Planning Application Ref: A/25/20/DOC

Location: New Place Nursery, Land at Arundel Road, Angmering, BN16 4ET

Description of works: Approval of details reserved by condition imposed under ref A/131/16/OUT relating to Condition No 4 - surface water drainage

Mark Warwick
Tree Officer / Parks and Greenspace Team

Rev	A	Services	07.05.20
Drawing Title			
Detailed Tree Protection Plan			
Client	GD Group	Date	22.10.19
Project	Arundel Road, Angmering	Drawing Ref	DTPP
Scale	1:250@A2	Job Number	1911
Drawn	JLD		
The Urban Forest Consultancy			
W www.ufctrees.co.uk E joanna@ufctrees.co.uk M 07968021337

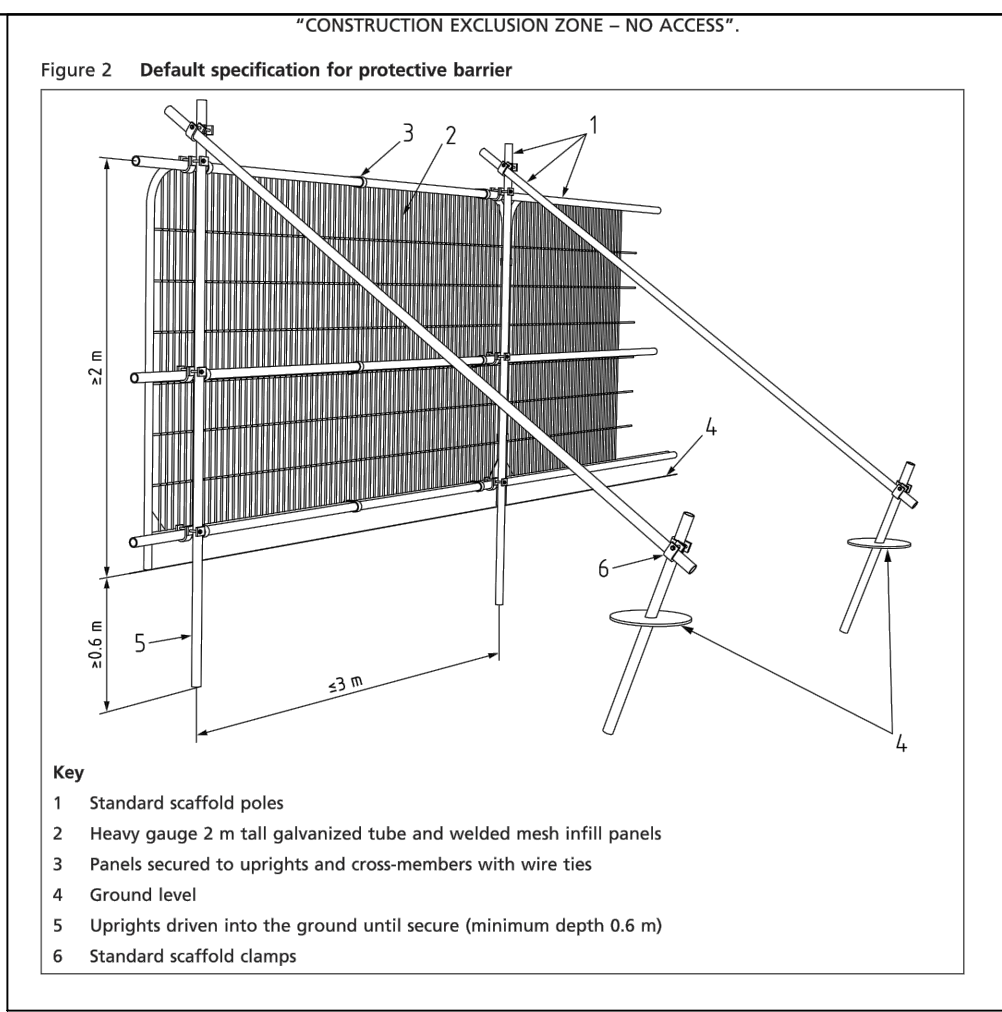
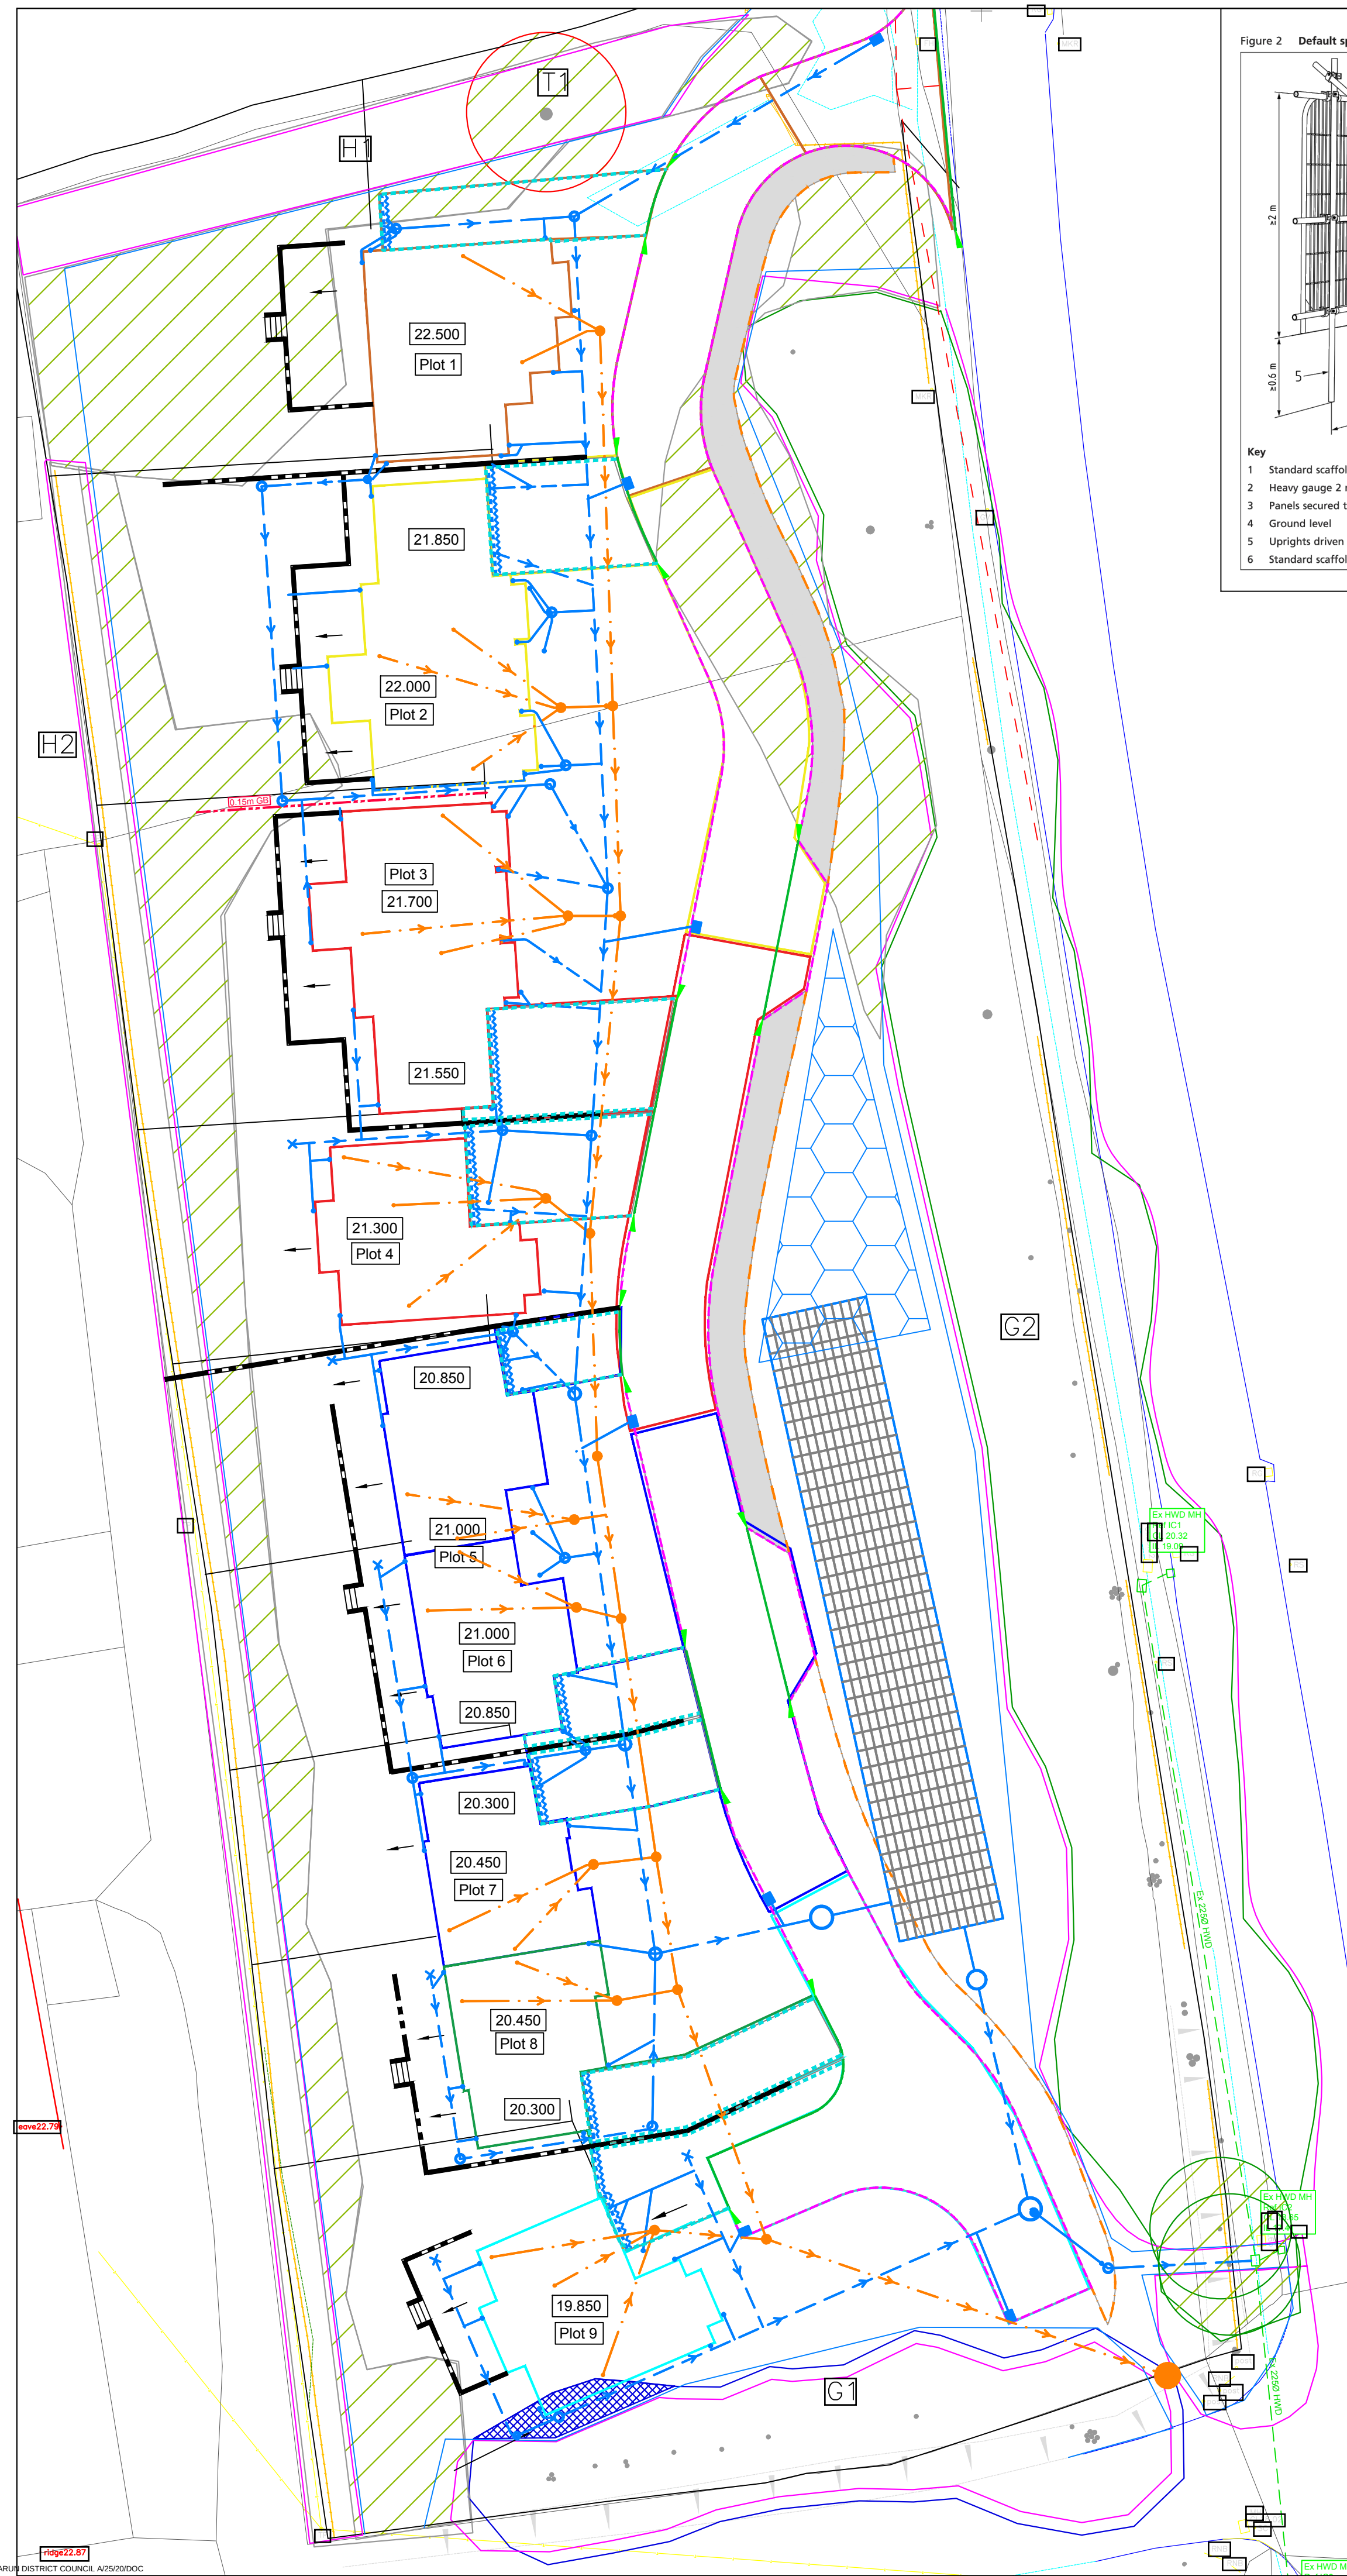
- 14.1 Key activities for supervision include; Erection/Dismantling of Tree Protection Barriers, Ground works and services within RPA.
- The applicants have instructed The Urban Forest Consultancy to revise the above Arboricultural Method Statement inclusive of Tree Protection Plan (Rev A) in support of the latest Drainage Layout proposal, Dwg. No. 100, Rev.P5 from CGS Civils.

- It is encouraging to note the re-alignment (this must be secured to site hoarding) of tree protective fencing to achieve an effective construction exclusion zone either side of the proposed service installation work, thus limiting the damage to retained trees. Maximum 3m wide working zone. **This should be installed as described here and 'signed off' by project arboriculturist prior to any work within RPA of G2.**

- The work zone looks to have a width of 2.5 -3.0 metres which I expect to be adequate room for the operation.
 - **The Tree Protection Plan (Rev A) does not replicate the latest drainage layout around Plot 9 and so will need to be further revised.**
